**MAJOR PROJECT ASSESSMENT:
Mixed Use Residential, Retail and
Commercial Development
330 Church Street, Parramatta
(MP 10_0171)**

Director-General's
Environmental Assessment Report
Section 75I of the
Environmental Planning and Assessment Act 1979

October 2012

01 PLAN - PARKING LEVEL 04
1:200 @ A1

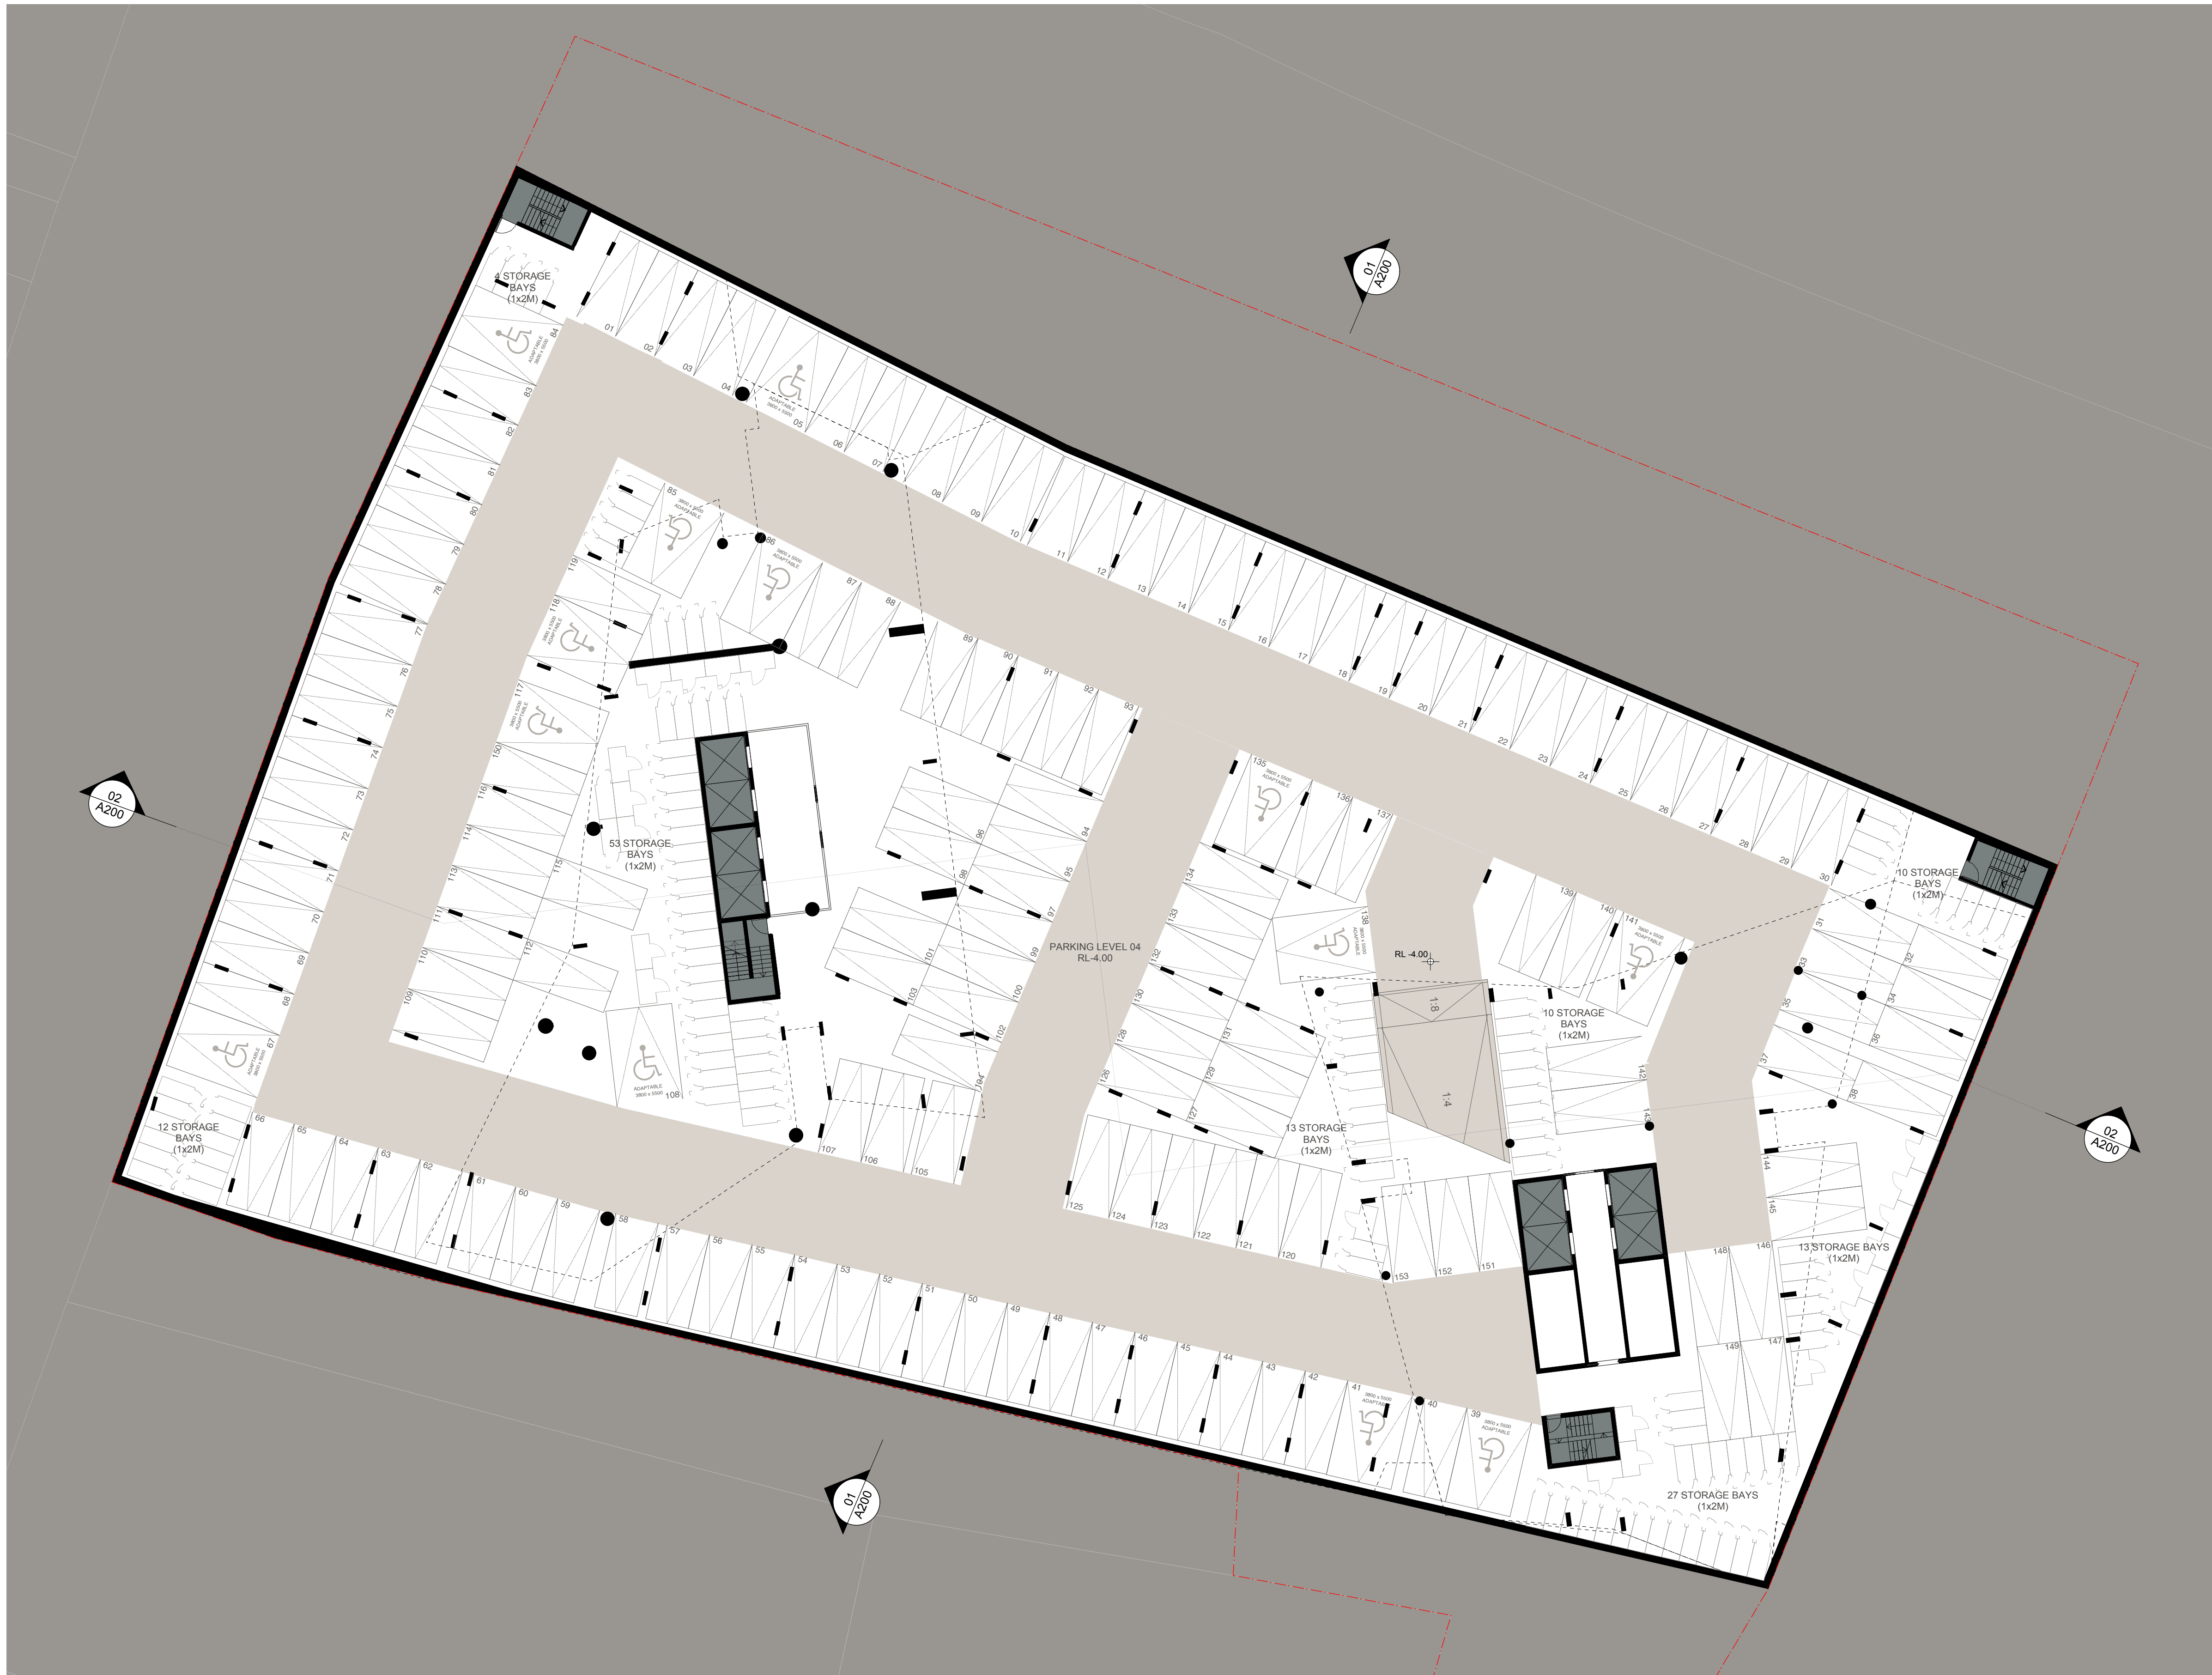
- Stacked car parking spaces should not be used by multiple building tenants or building occupants. To manage this issue a condition should be imposed to allocate stacked parking spaces to specific tenants.
- The disabled/adaptable parking spaces within basement levels 2 to 4 do not comply with AS 2890.6-2009.

- As there are a number of drawing errors and non-compliances with AS 2890.6-2009 and the RFDC, the department requested that the proponent address these issues in its PPR.

The department notes that the basement car park plans have been revised to specify that all stacked spaces can not be used by multiple building owners or tenants.

SOLAR ACCESS DIAGRAM - WESTERN TOWER

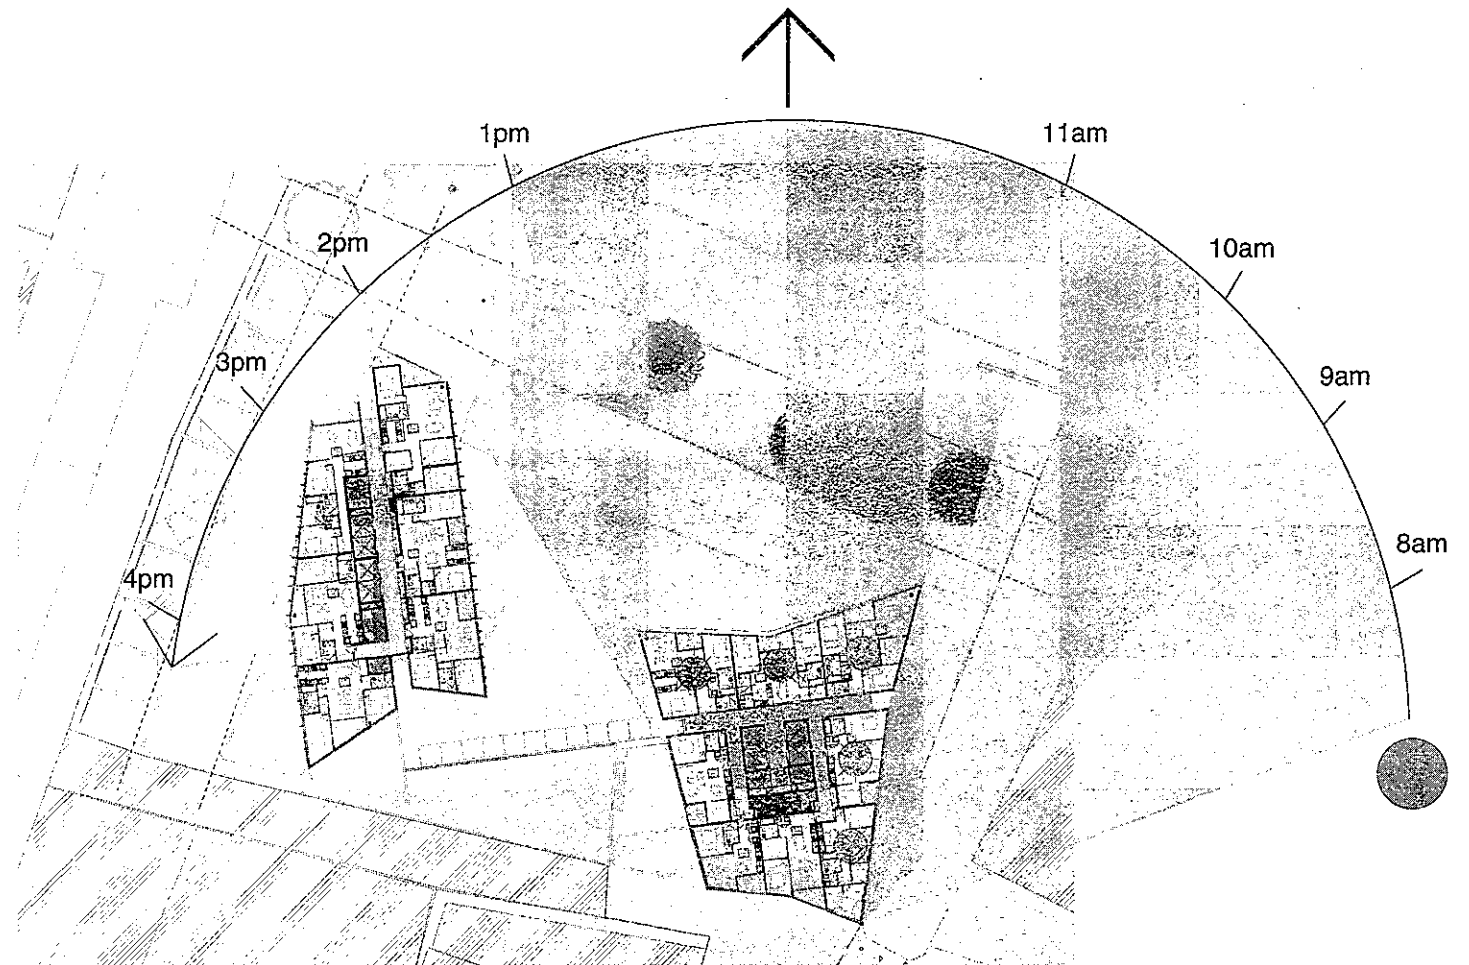
- The proponent has not justified the proposed reduction to the minimum three hour solar access requirements for residential flat buildings.
- The application is inconsistent with the finished floor levels identified in the Riverbank Site Controls (RL 6.5 recommended, up to RL 8.9 proposed). The variations proposed to the Riverbank Controls would create an inappropriate transition between the site, the foreshore and the public square proposed to the east of the site, and may result in the development not achieving disabled access.

- The use of the two hour solar access criterion is consistent with the requirements of the Residential Flat Design Code (RFDC), which permits the use of the two hour solar access criterion in CBD locations.
